Re: The Dairy, Roads Hill, Horndean, Waterlooville, PO8 0TG

Thank you for your recent pre-application enquiry and supporting documents.

AMENDMENTS	DATE
CLIENT Cornerstone Development	
PROJECT The Dairy - New Build Development The Dairy, Roads Hill, Waterlooville, Hampshire, PO8 0TG	
DRAWING TITLE Master Site Plan	
DATE 01/12/2020	
SCALE 1 : 400	
DRAWING No. 20.020.SP 02H2	REVISION

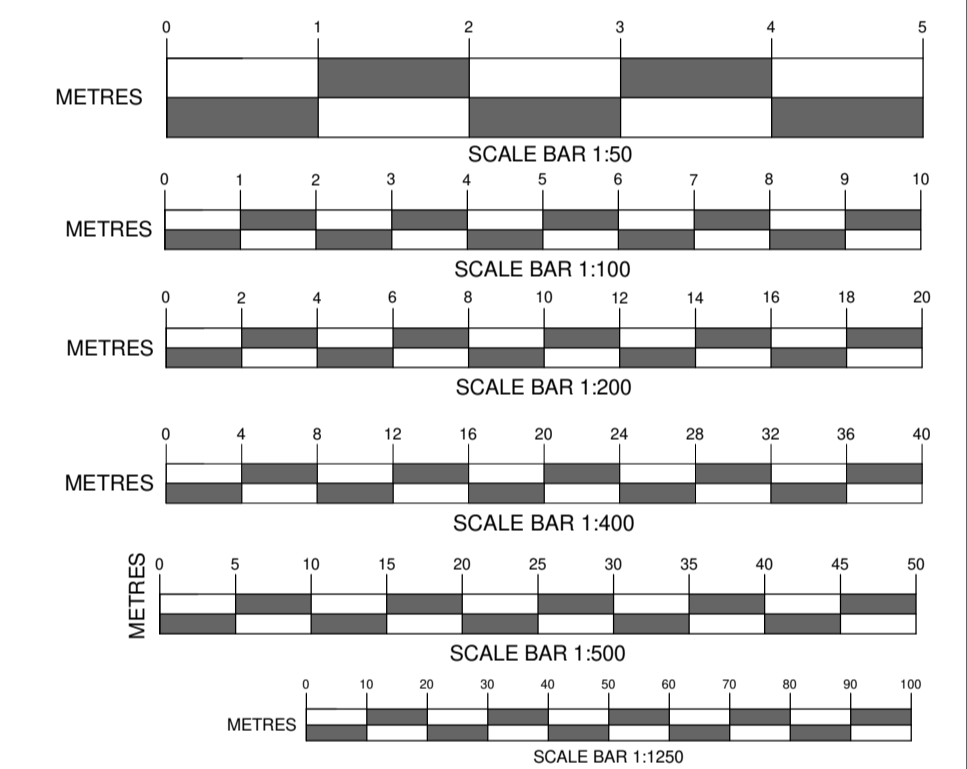
You will note the threshold for affordable housing being 1,000sqm. No details of the houses have been presented and I'm not clear if the layout plan submitted is intended to be illustrative to show how the site may accommodate nine dwellings, however, I have concerns with how rigid the layout appears, with buildings and access appearing to be laid out without being informed by regard to landscape character. No landscaping is shown and the layout appears at odds with the rural character. The proposed access to the commercial unit at the junction looks poor but the County Council offer their own pre-application service and I would suggest using this if proposing such an access.
